Planning Application Ref: A/54/14/TC

Location : St Margarets Church, Arundel Road, Angmering

Description of works: Fell 4 x Wild Plums + 1 x Western Red Cedar + remove limb of Sycamore + cut back limb of a Sycamore

Trees to be felled (on safety grounds) , roots ground out and 4 new trees planted.
(2 no. Liquidambar Straciflua and 2 no. Acer Negundo)

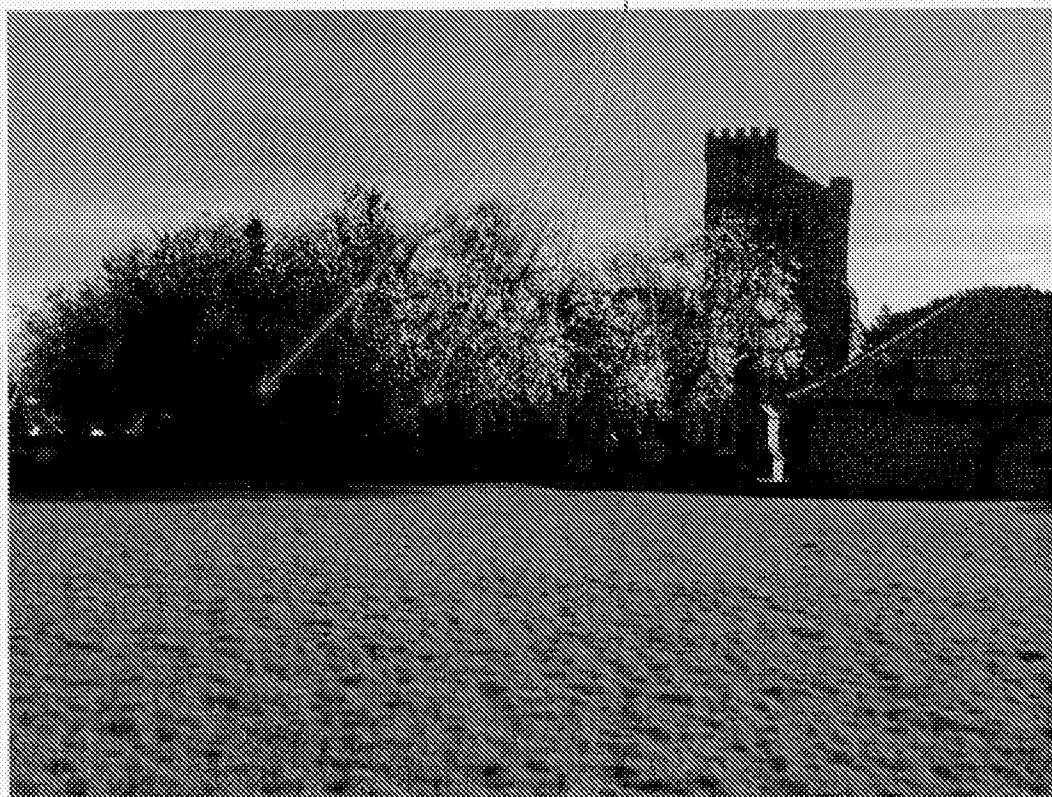
G3 Myrobalan Plums *Prunus cerasifera* Height = 4-6m Avge spread = 3-4m Age = Mature

- All of these trees have reached the end of their safe useful life at this location and are full of heart rot fungi.
- The replacement with 2 x **Sweet Gums** and 2 x **Box Elders** will enhance the Conservation Area.

(T6) Sycamore to the west of the churchyard
One limb to be felled (on safety grounds) where it has grown around the railings to a grave
weakening the tree.

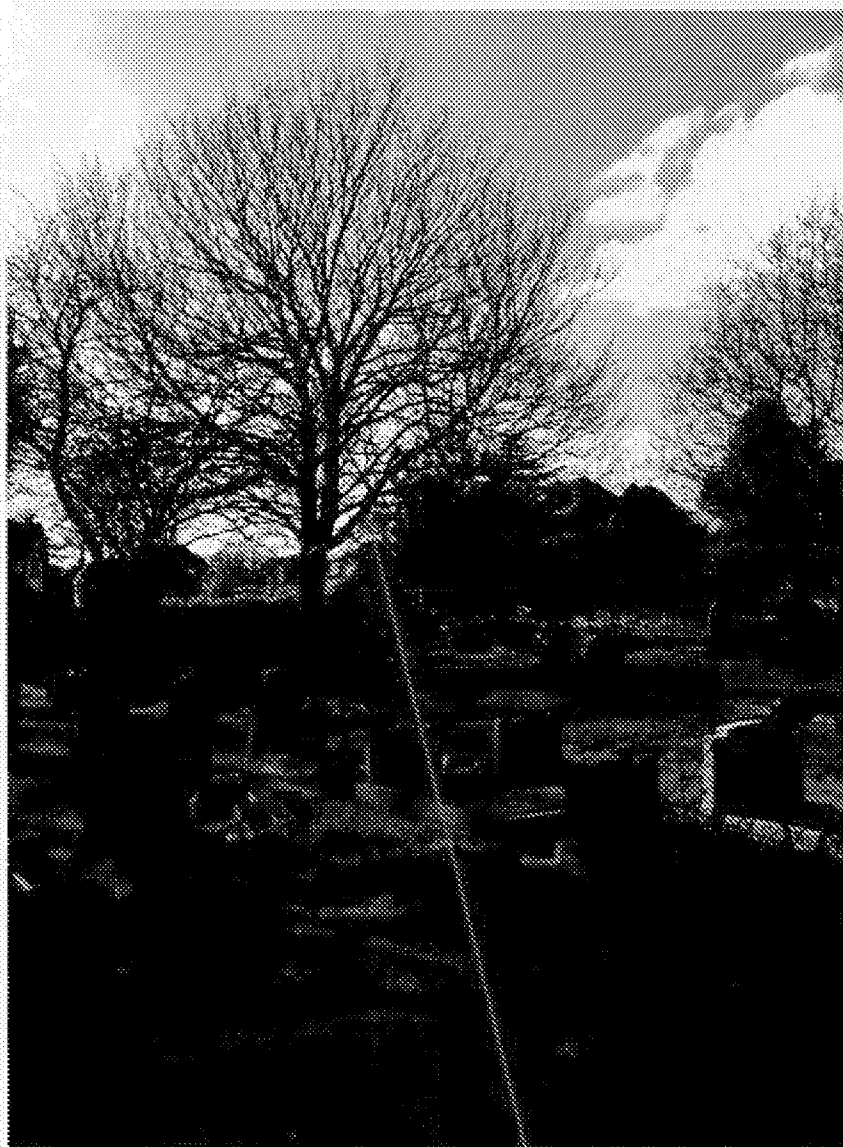
T5 Sycamore *Acer pseudoplatanus* Height = 18m Avge spread = 8m Age = Early Mature

- This self seeded tree has grown up between graves and engulfed stones and ironwork in the process.
- The removal of this limb will only solve part of the problem and I suspect that this tree and the young Yew next to it will eventually have to be removed.

(T8) Sycamore to the western boundary
Limb to be pruned back (on safety grounds) where it has become overly long with the risk it falling as its weight increases.

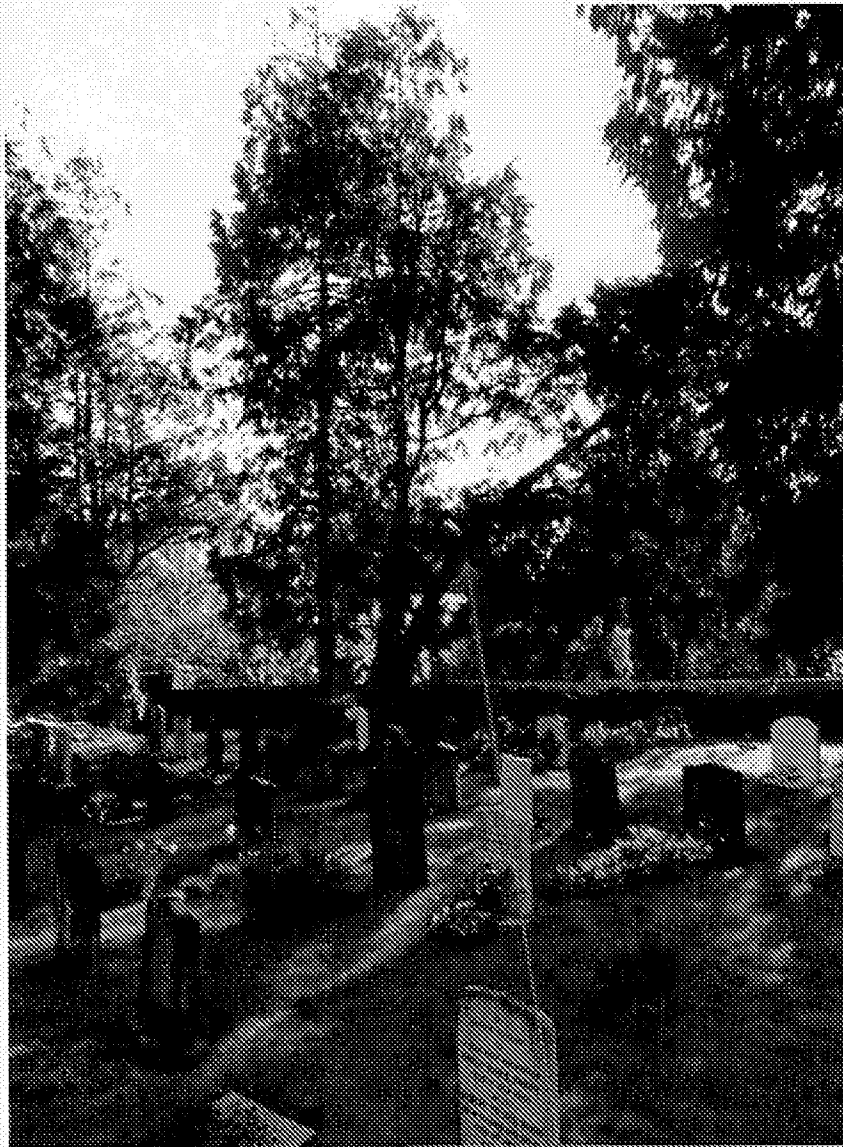
T8 Sycamore *Acer pseudoplatanus* Height = 20m Avge spread = 10m Age = Early Mature

- An off site tree with low branch overhang of the site boundary line causing a nuisance – shortening back this tree will abate the nuisance and have minimal impact on its visual amenity value

(T9) Western Red Cedar to the west boundary
Leaning limb to be felled (on safety grounds) where this is leaning at a dangerous angle over the road.

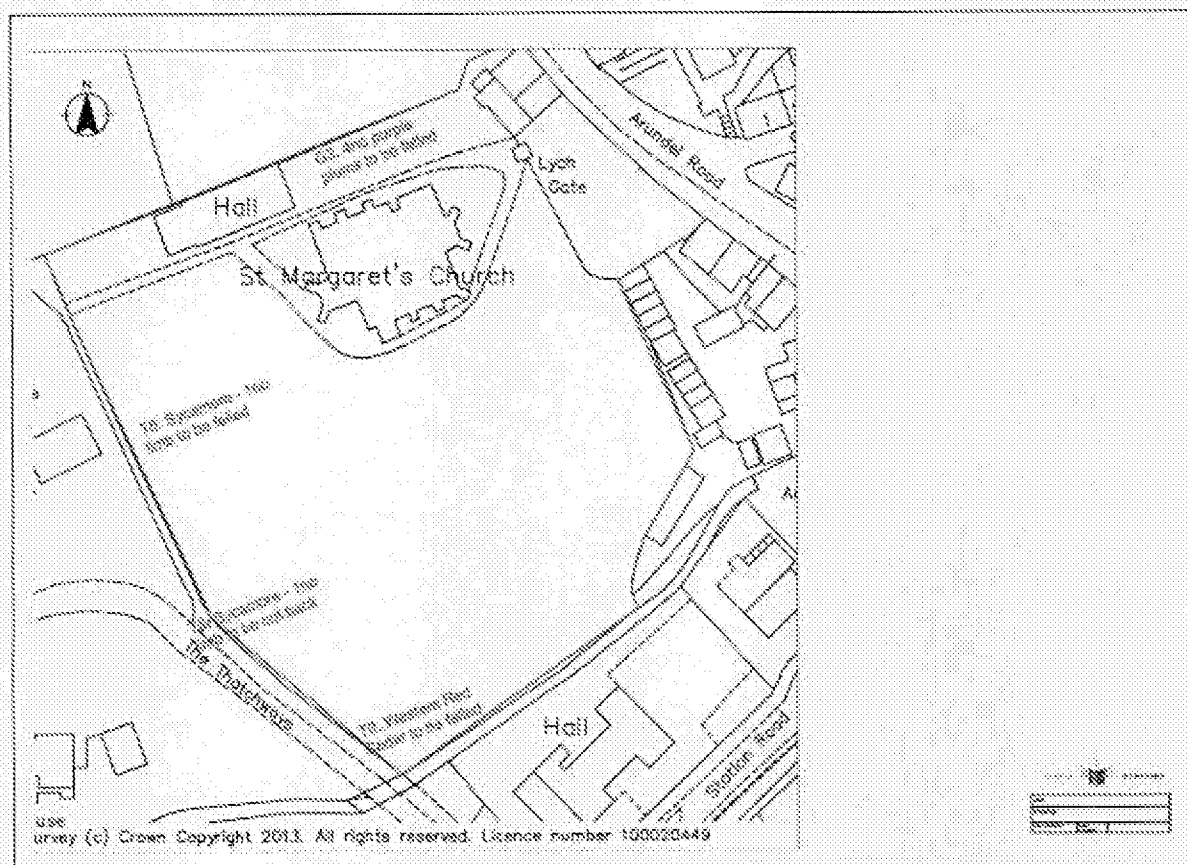
T9 Western Red Cedar *Thuja plicata* Height = 14m Avge spread = 1.5m Age = Semi Mature

- This tree has one arching limb that grows out above the road – its removal would balance the tree and make safe and improve its general appearance.
